Portishead Branch Line MetroWest Phase 1: Schedule of ExA's Recommended Amendments to the Applicant's Draft DCO submitted at Deadline (D)6 [REP6 – 008]

Residents have now had an opportunity to consider the ExA's recommended amendments in relation to Schedule 2 New Requirements regarding the Pill Tunnel Eastern Portal Compound Access and have instructed me to make a supplementary submission the effect of which is to vary my Deadline 6 submission of 15th March 2021.

Drawing **PILL TUNNEL EASTERN PORTAL COMPOUND LANDSCAPING & ACCESS PLAN SHEET 1 OF 2**

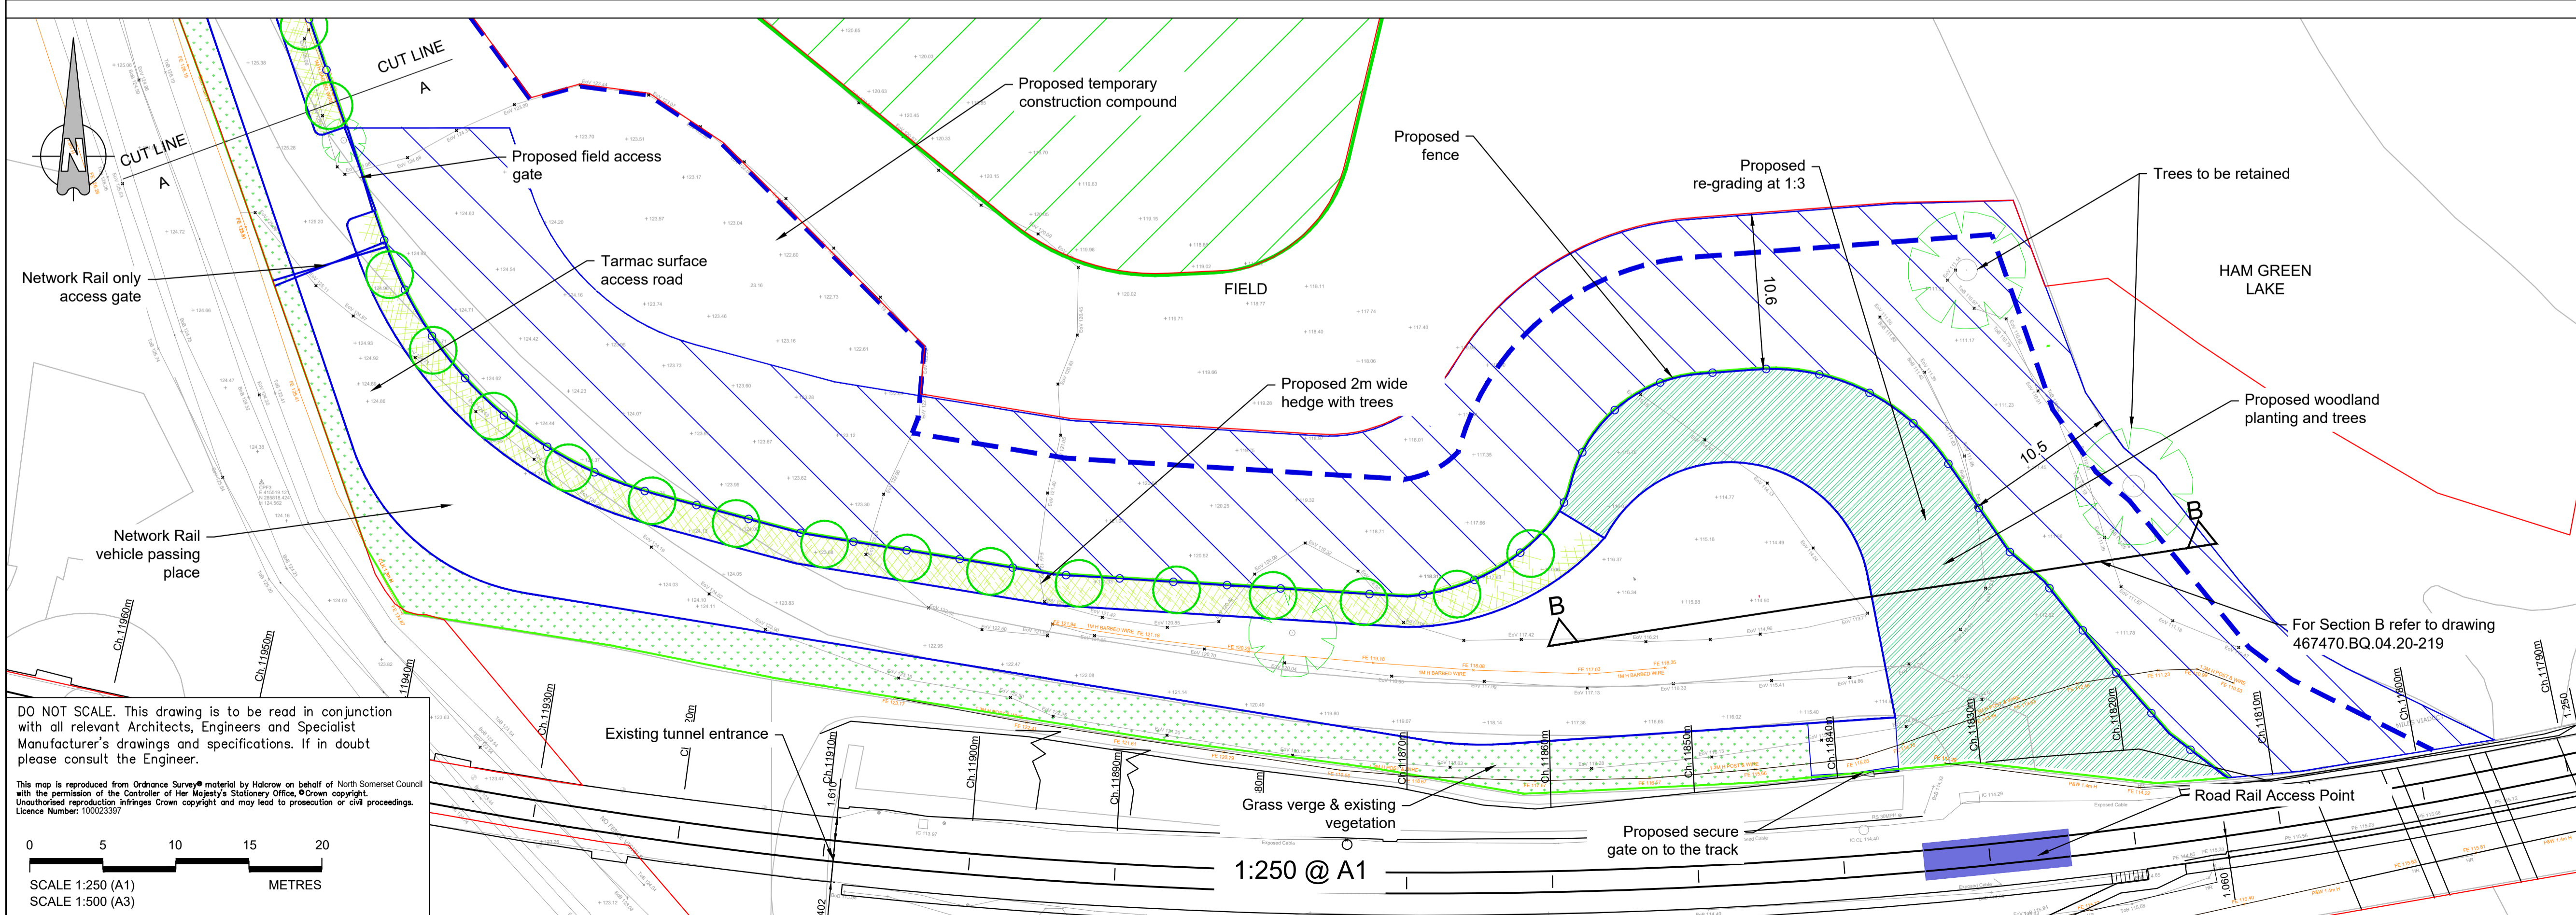
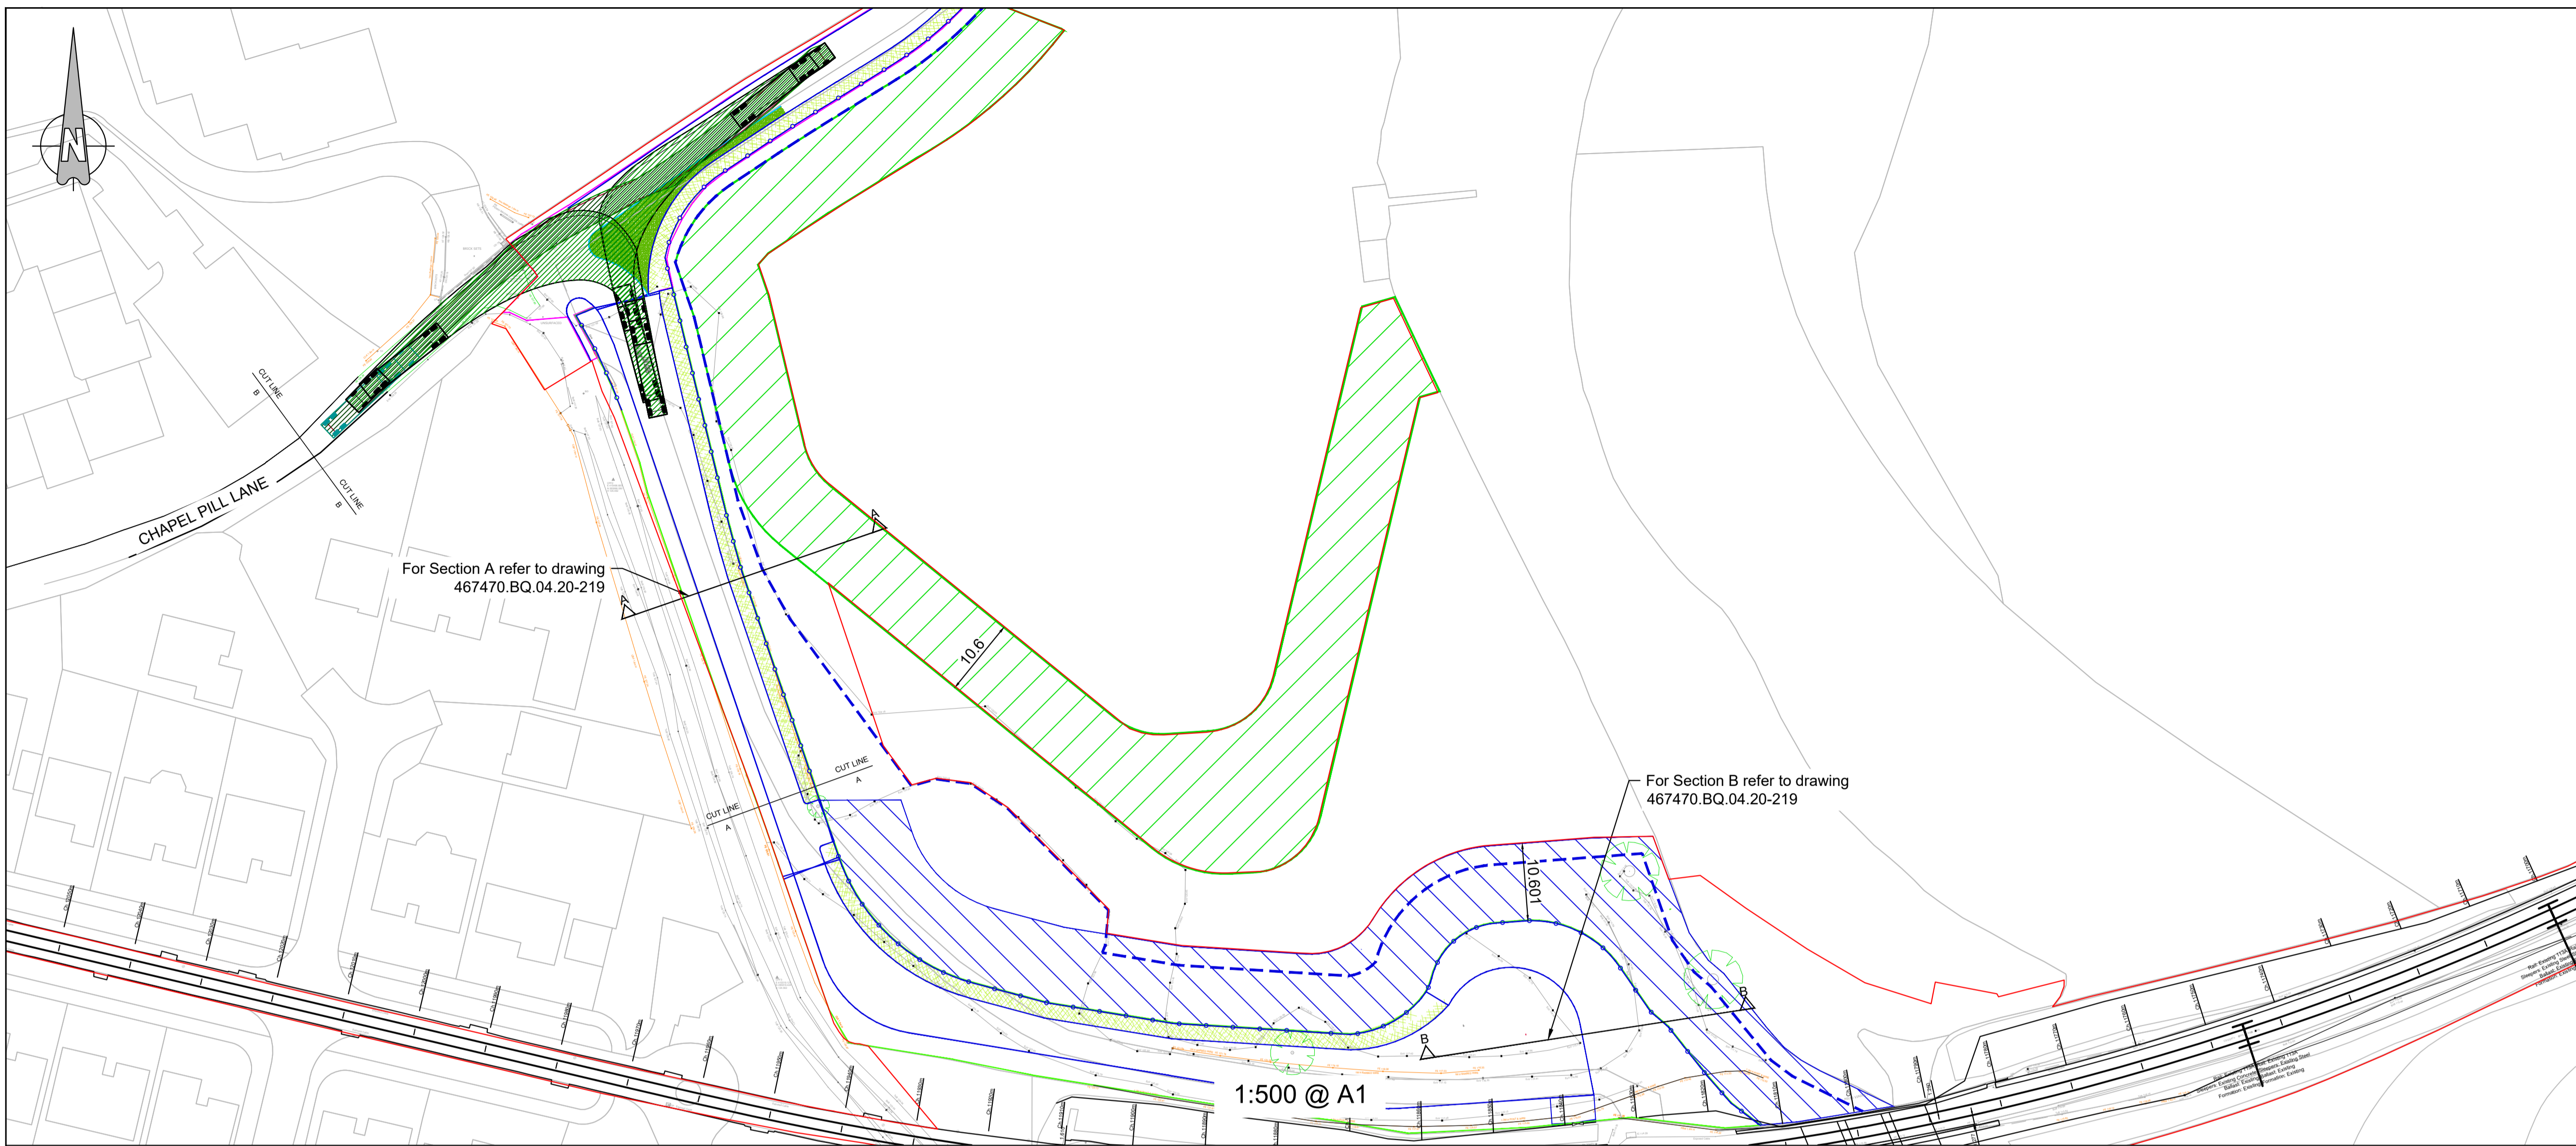
The submission is that pursuant to Schedule 2 Pill Tunnel Eastern Portal Compound Access recommended amendments the Planning Inspectorate should set a further condition requiring NSC (the Applicant for the MetroWest Phase 1 Project) to enter into an undertaking in perpetuity not to share or permit the use of or rights of way over any part of the Chapel Pill Lane site entrance or access track with any other user except the owner of the field and his agricultural contractors, the beneficiary of the Right of Way over the field and those to whom he grants permissive access, Network Rail and their contractors, rail accident emergency responders (the Police, Fire and Rescue Service, the Ambulance Service and emergency contractors), Government departments and their rail accident and safety inspectors (principally the Department of Transport and the Health and Safety Executive). In effect this would be a restrictive covenant the precise usage coverage and the drafting of which would need to be undertaken by lawyers.

Residents have also asked me to emphasise that concrete cellular blocks should be used on all track and turning surfaces consistent with maintaining the openness and appearance of Green Belt where the gradient and conditions allow; that only exceptionally where it is operationally justified, for example on the steepest part of the track within the field, should tarmac be used.

2.56, Important Hedgerow Plan

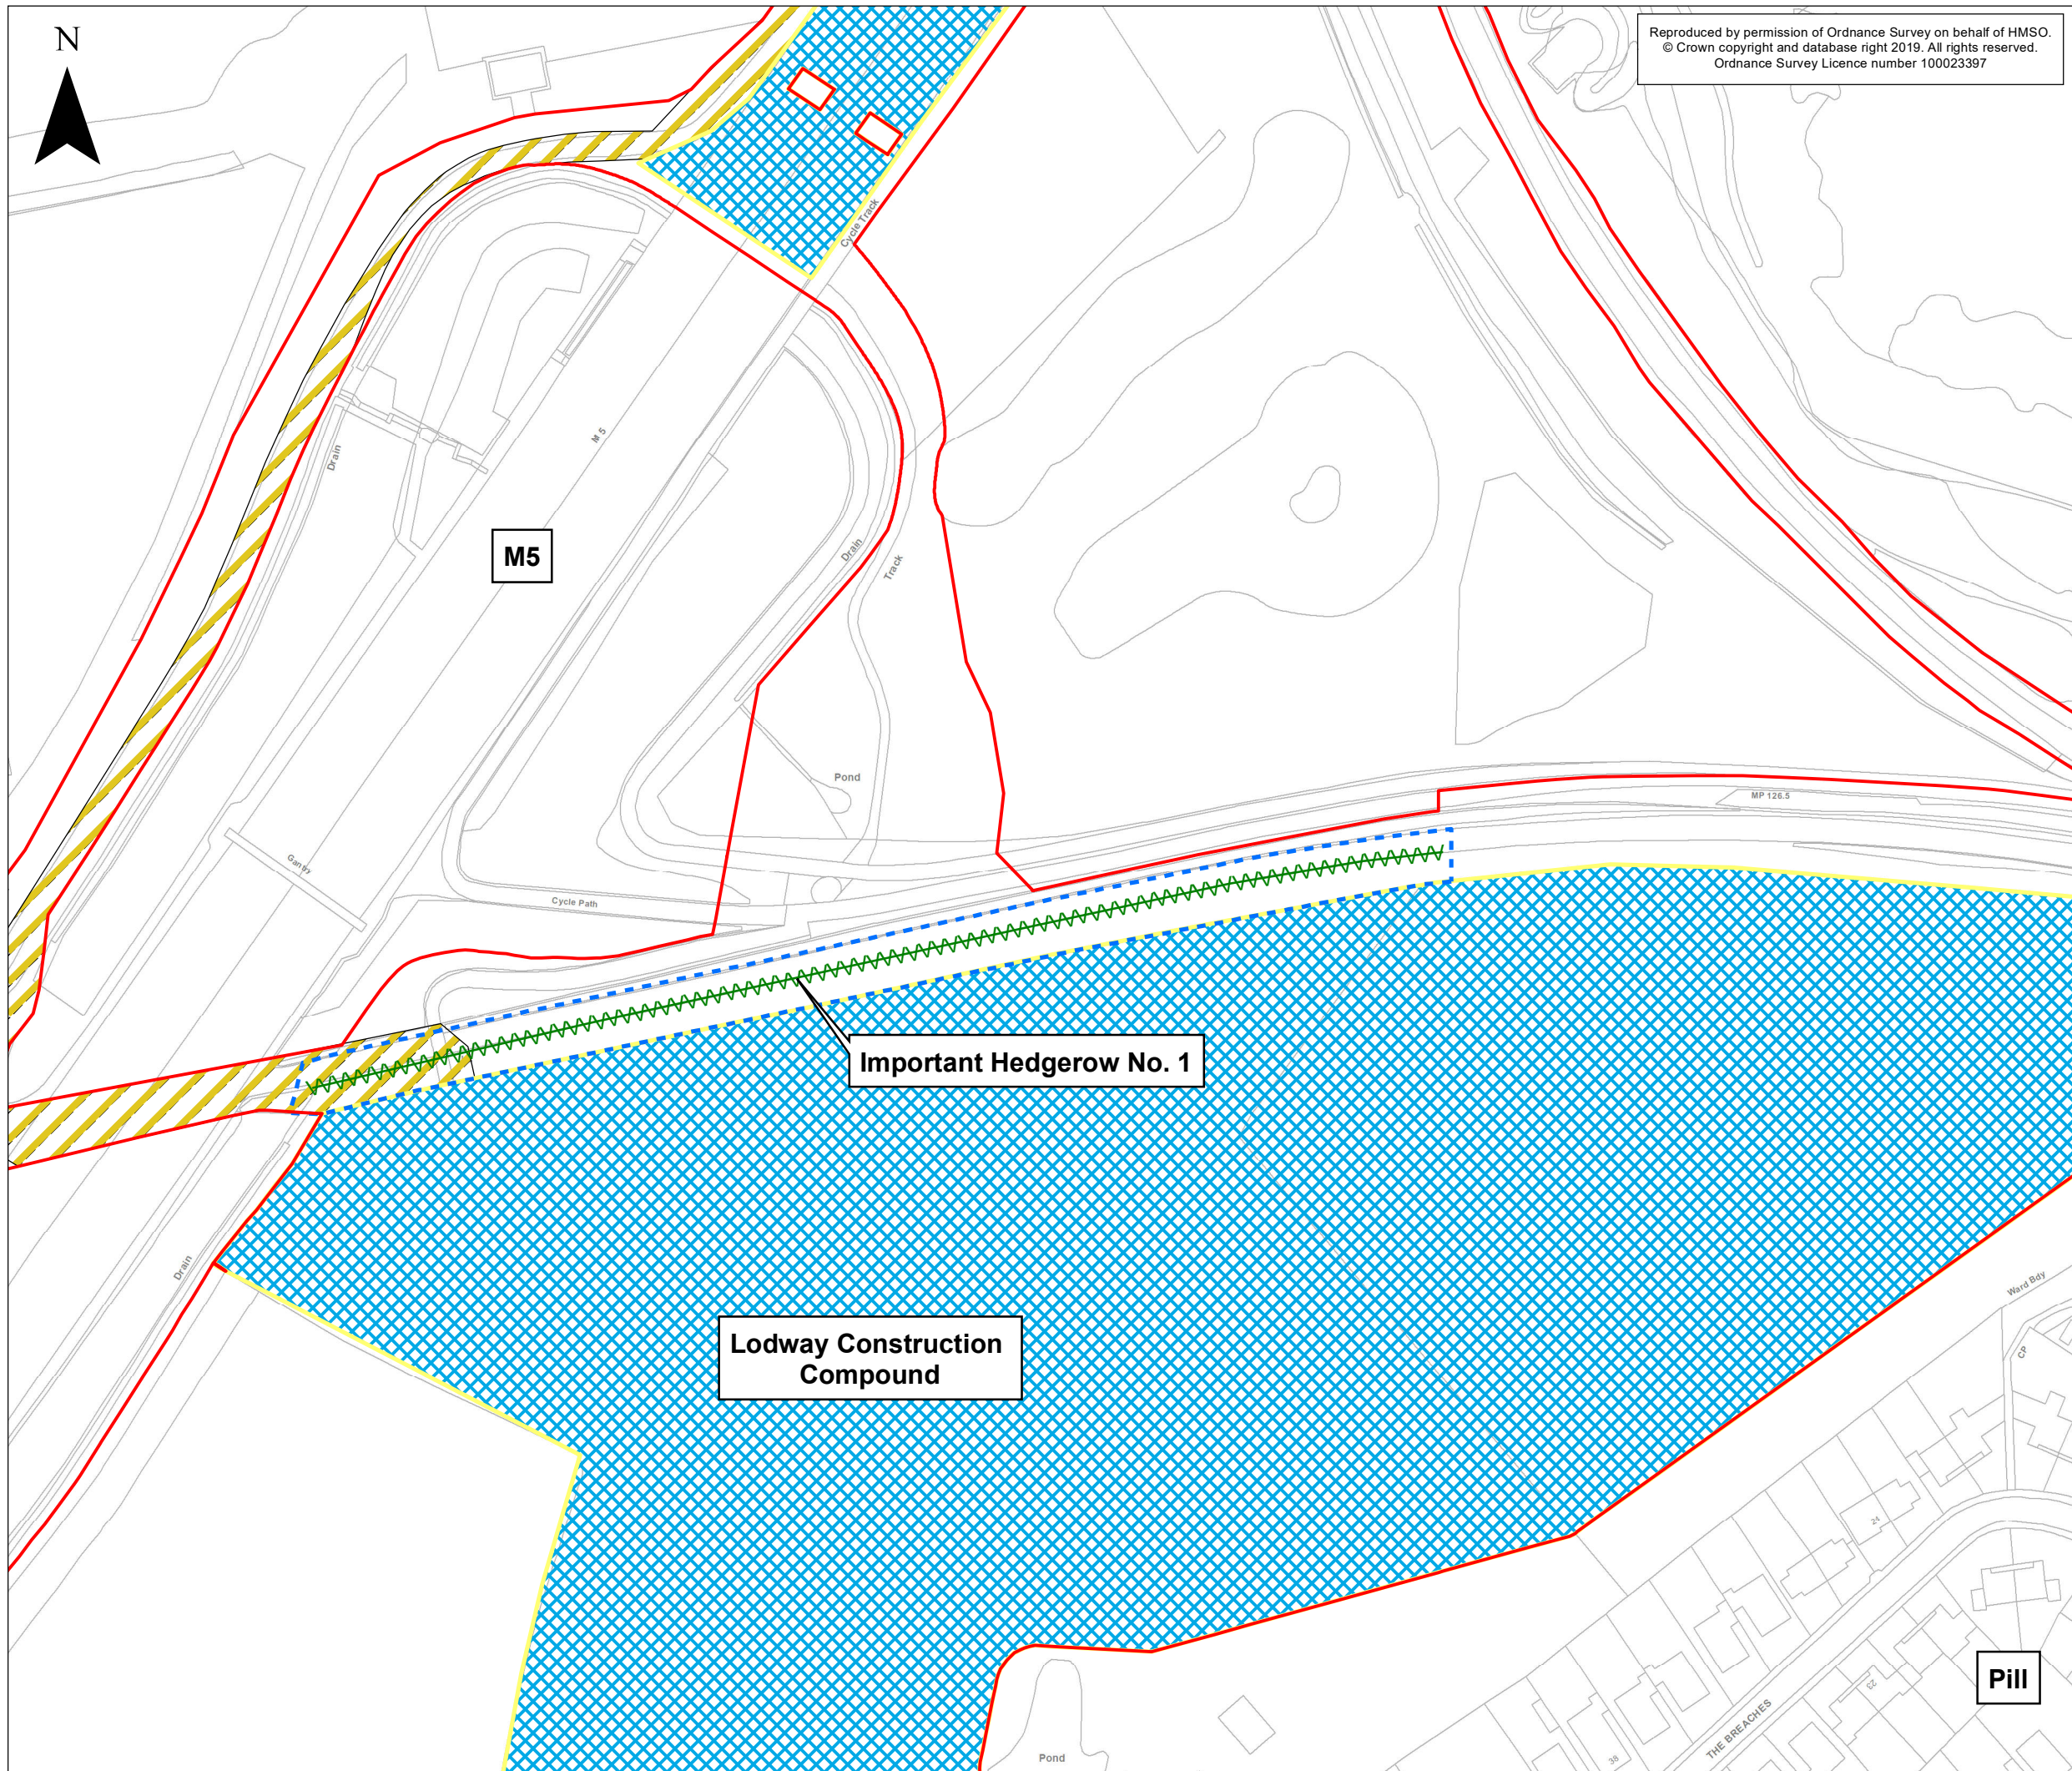
Finally, residents have confirmed that they would be prepared not to pursue any previous requests for Hayes Mayes Lane to be used as an alternative means of access to the Pill Tunnel compound if these conditions are agreed, in order to protect the hedgerow, tree line and the important wildlife habitats within designated Green Belt that they provide. In addition, an

assurance should be sought that MetroWest (Network Rail and its contractors) will have no future need to breach the hedgerow and tree line which provides an important buffer between Hayes Mayes Lane and Hart Close once access to the compound via Chapel Pill Lane subject to these conditions has been confirmed.
